**Your Ref: 2025/90320**

**Our Ref: A007160**

**Jewson Property And Services Division, St Andrew's Road, Huddersfield - Erection of extension to existing warehouse; demolition of warehouse entrance canopy and southern section of existing warehouse; demolition of existing timber storage area and erection of covered external racking area and associated works**

**Yorkshire Water object to the site layout as shown on the submitted drawing 24399-DR-C-0102 dated December 2024 that has been prepared by Topping Engineers because it shows the proposed extension to be sited within an easement.**

Proposed Layout Plan Showing Catchment Areas (1:1000)

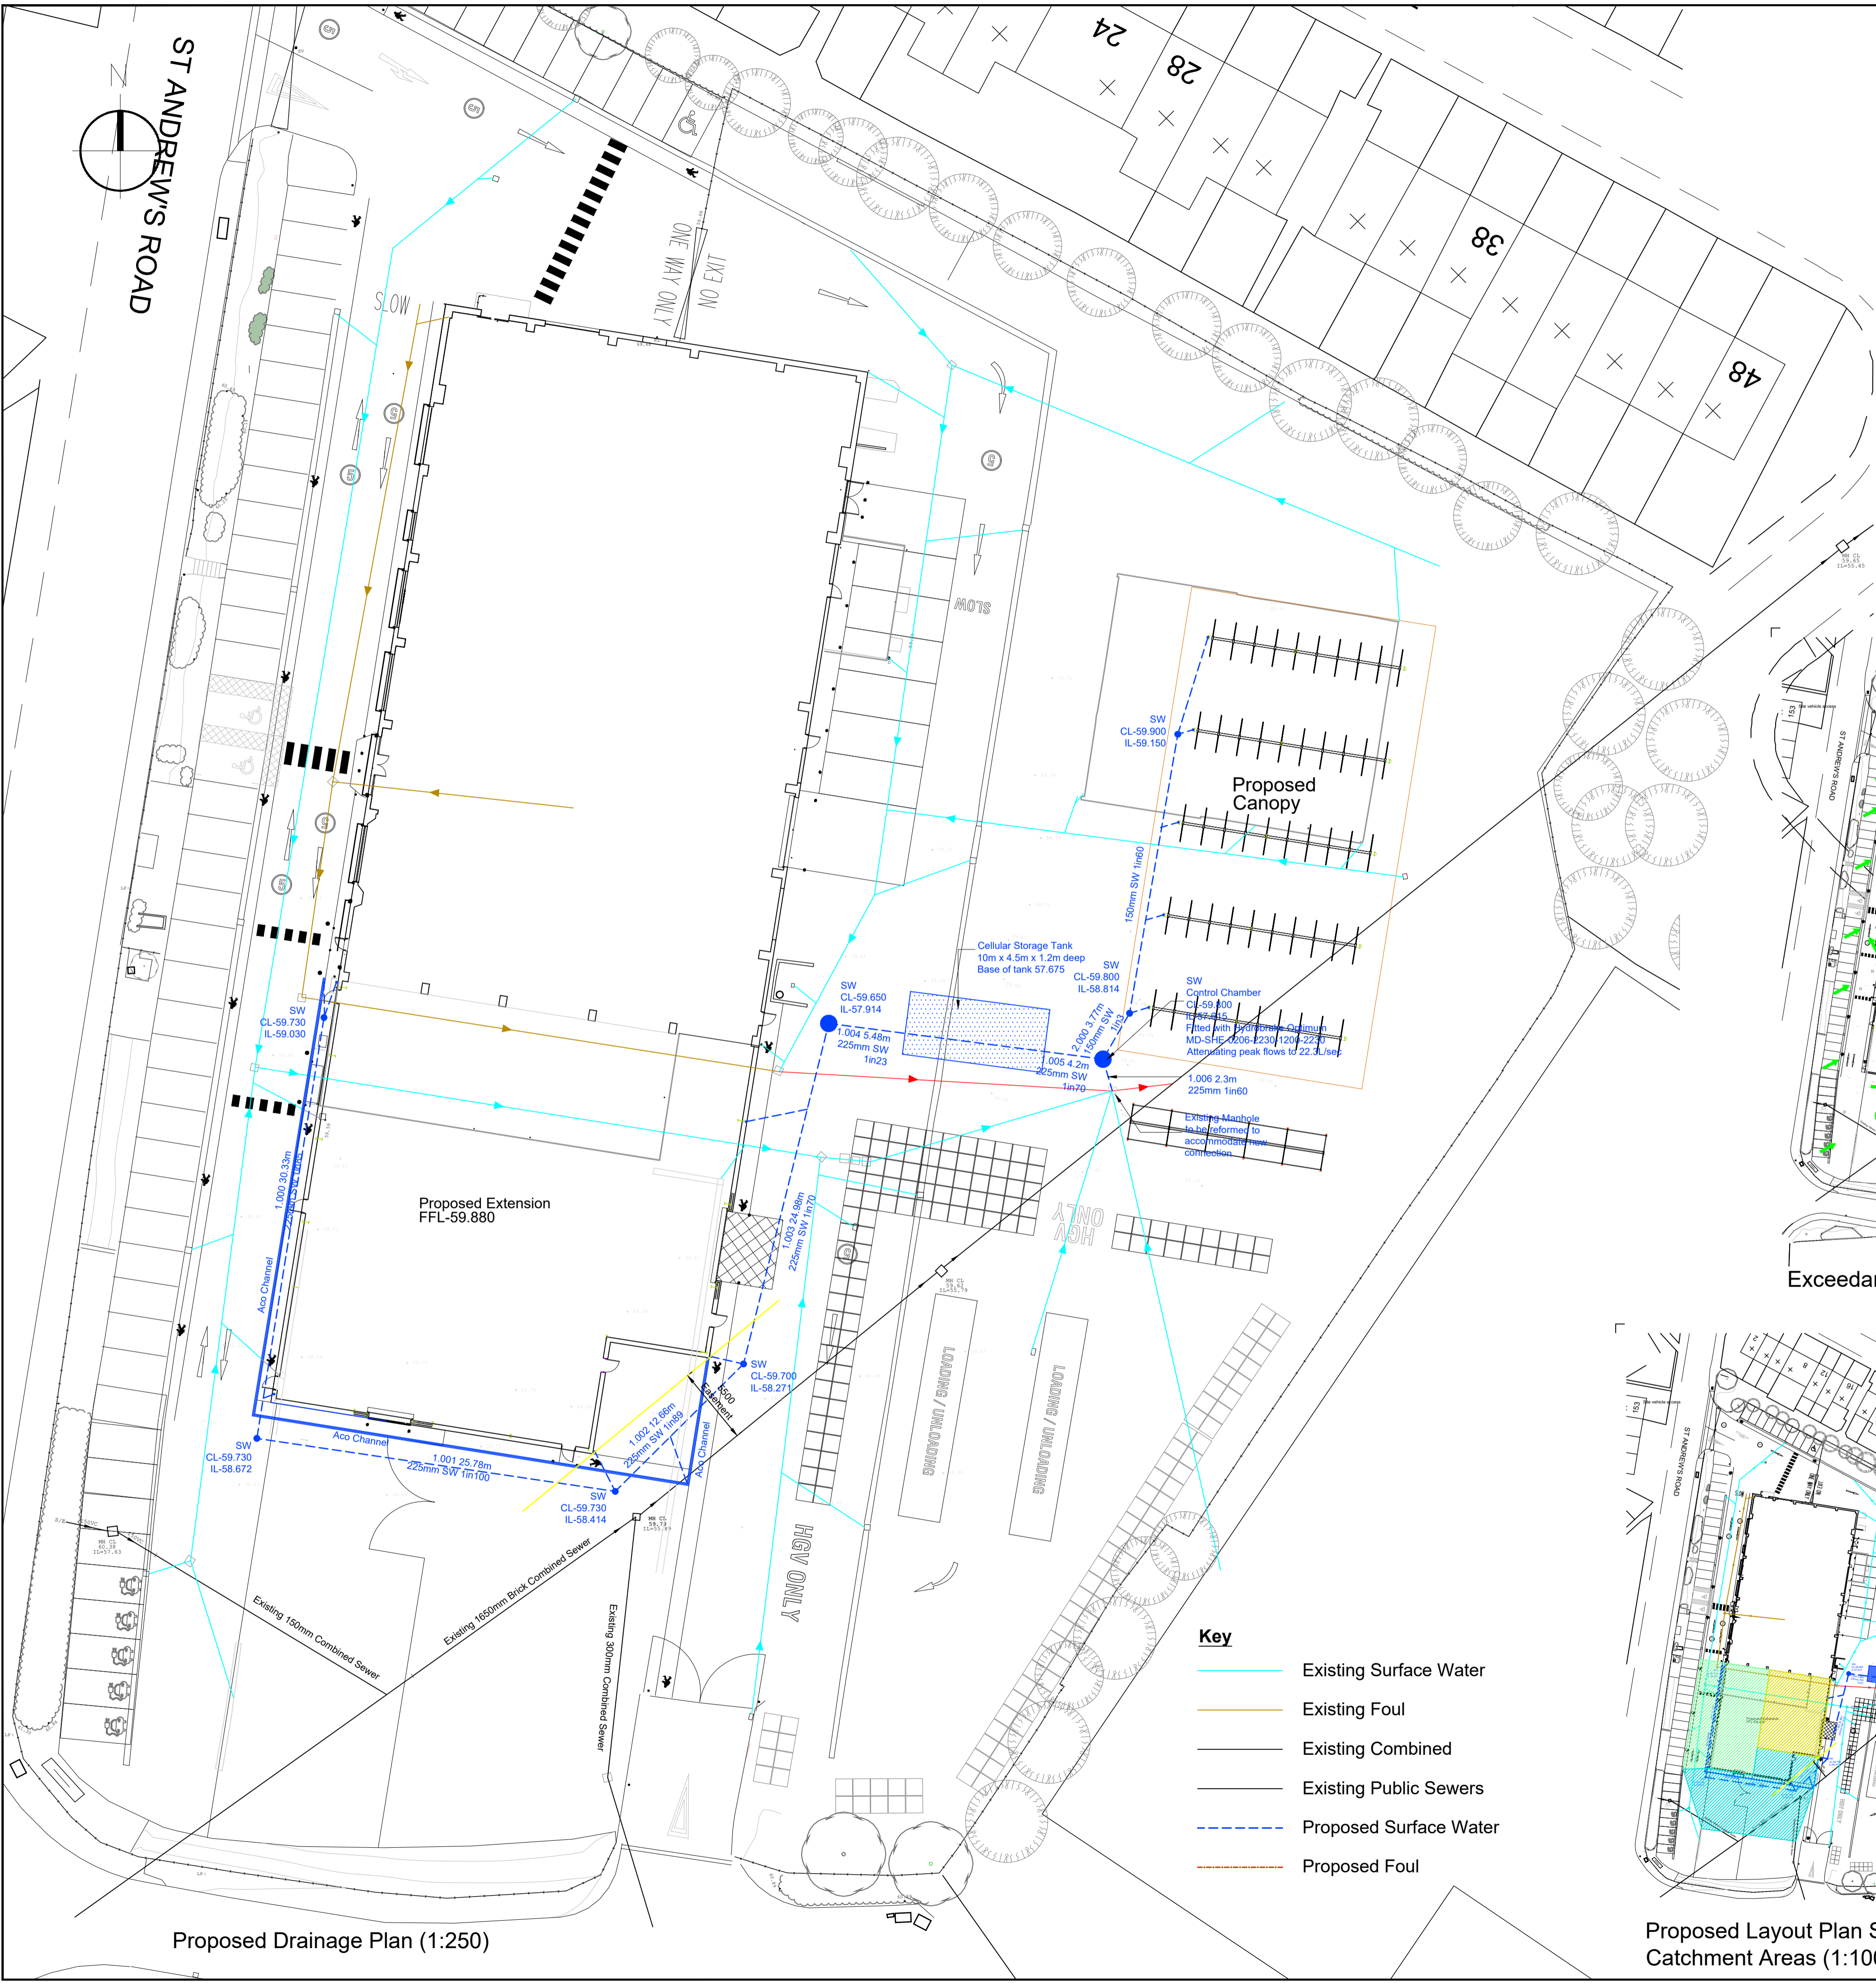
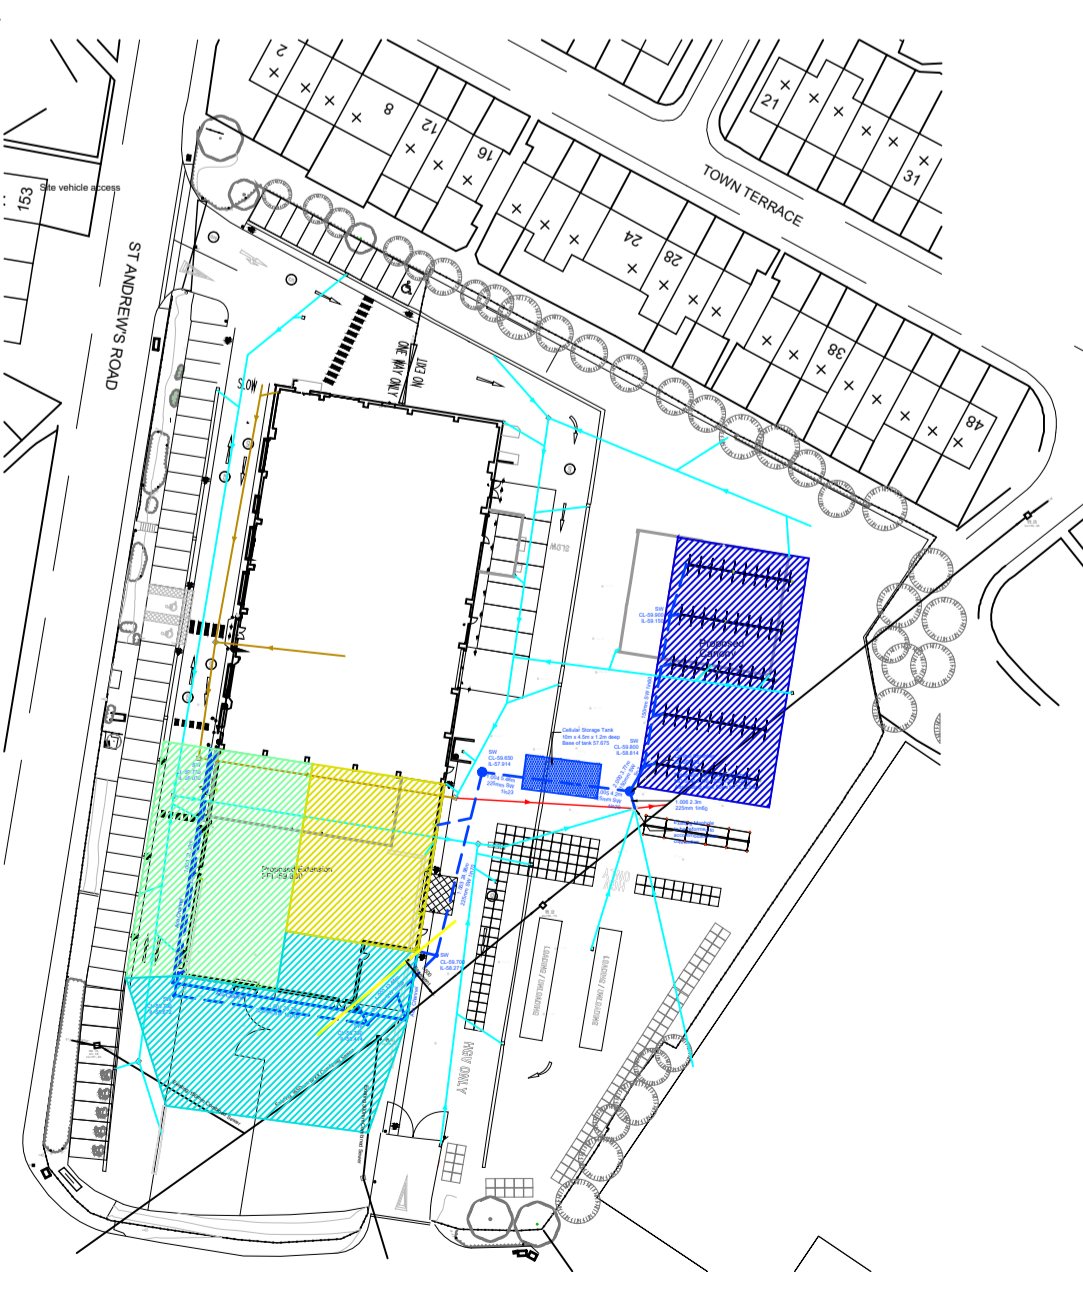
1) The drainage details submitted on drawing 24399-DR-C-0102 dated December 2024 that has been prepared by Topping Engineers require amendments. The following points should be addressed:

- a) the submitted drawing appears to show a building proposed to be built within a public sewer easement
- b) the submitted drawing should show the required building stand-off from public sewer or an agreed alternative scheme

2) On the Statutory Sewer Map, there is a 165mm, 300mm and 150mm diameter public combined water sewer recorded to cross the site. It is essential that the presence of this infrastructure is taken into account in the design of the scheme.

- a) It may not be acceptable to raise or lower ground levels over the sewer and we will not accept any inspection chambers on the sewer to be built over.
- b) In this instance, a stand-off distance of 6.5 (six point five) metres is required at each side of the 1650mm diameter combined sewer centre-line and it may not be acceptable to raise or lower ground levels over the sewer, nor to restrict access to the manholes on the sewer.
- c) In this instance, it would appear that the 150mm and 300mm diameter public sewer is unlikely to be affected by building-over proposals.
- d) A proposal by the developer to alter/divert a public sewer will be subject to Yorkshire Water's requirements and formal procedure in accordance with Section 185 Water Industry Act 1991.

3) Surface water run-off from communal parking (greater than 800 sq metres or more than 50 car parking spaces) and hardstanding must pass through an oil, petrol and grit interceptor/separator of adequate design before any discharge to the public sewer network. Roof water should not pass through the traditional 'stage' or full retention type of interceptor/separator and it is good drainage practice for any interceptor/separator to be located upstream of any on-site balancing, storage or other means of flow attenuation that may be required.
